# ENG-SF21012-R1-FDR-redlines.pdf Markup Summary

Add PCD File Number: PPR-21-017

UPLAND FLATS BY WATERMARK
 EL PASO COUNTY, COLORADO
 CONSTRUCTION DRAWING PLANS
 EXISTING DRAINAGE MAP

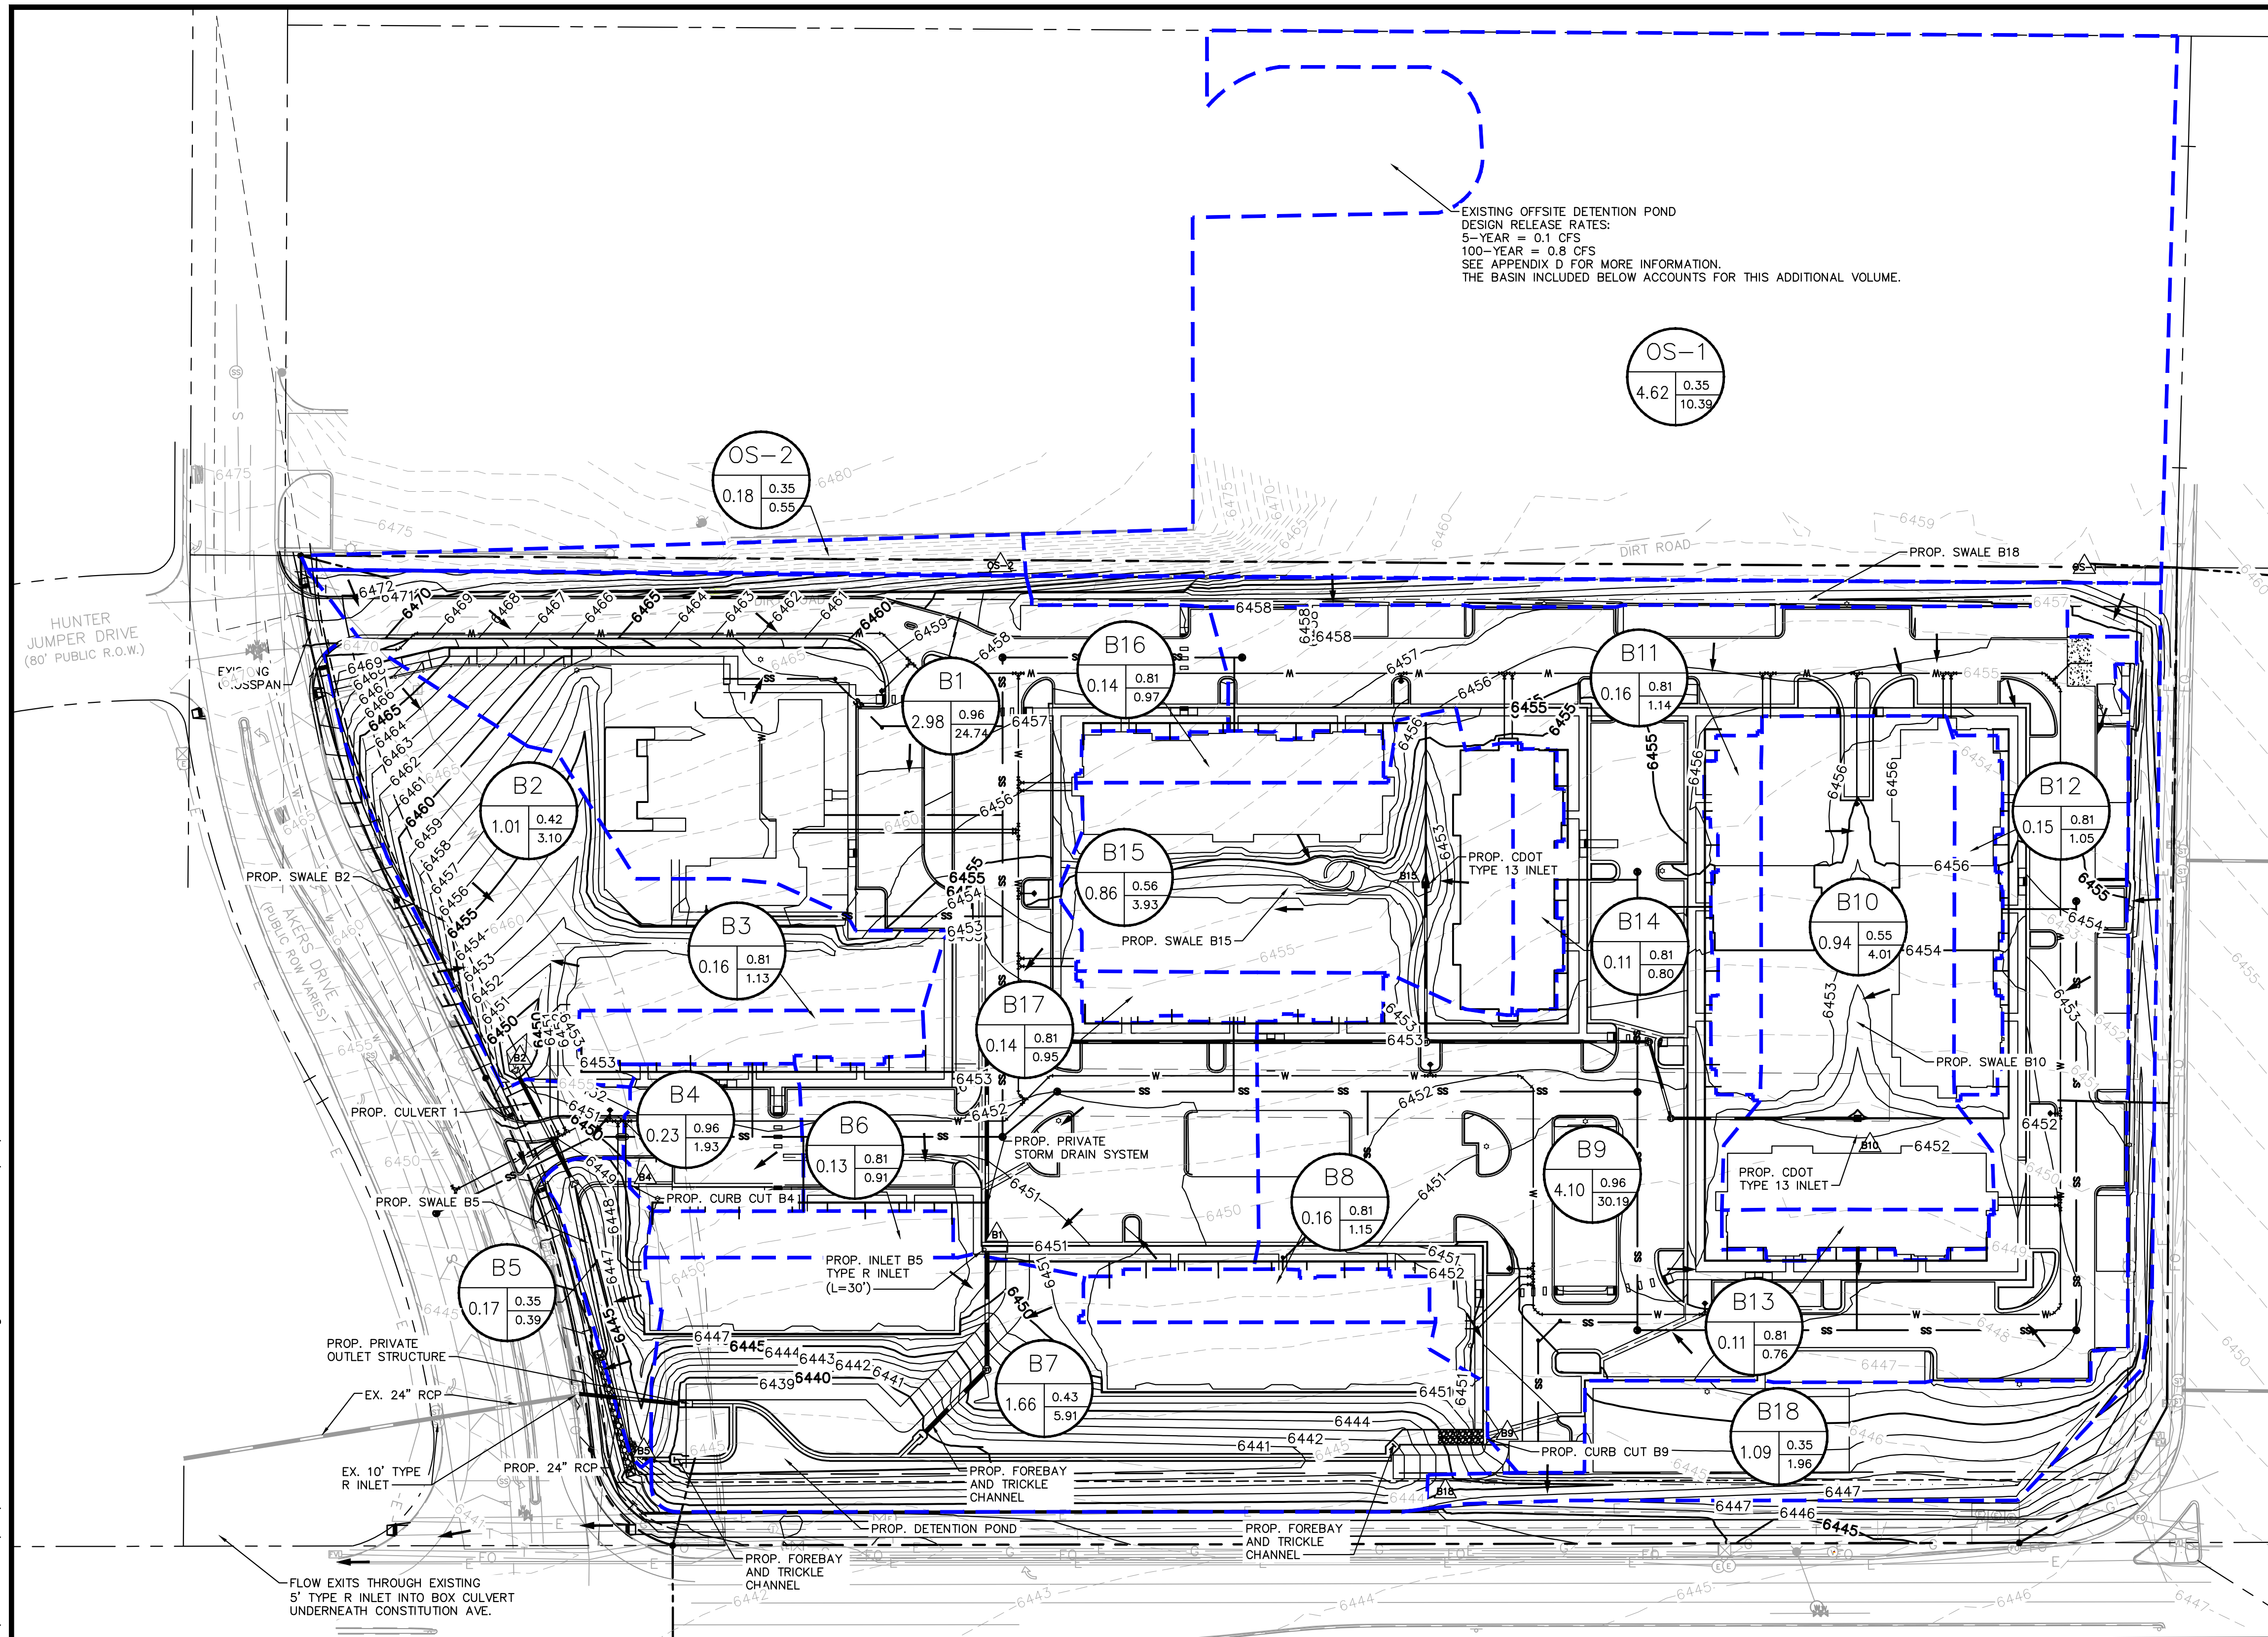
Identify the flow path to inlet and size of inlet

show and address all contributing sub-basins
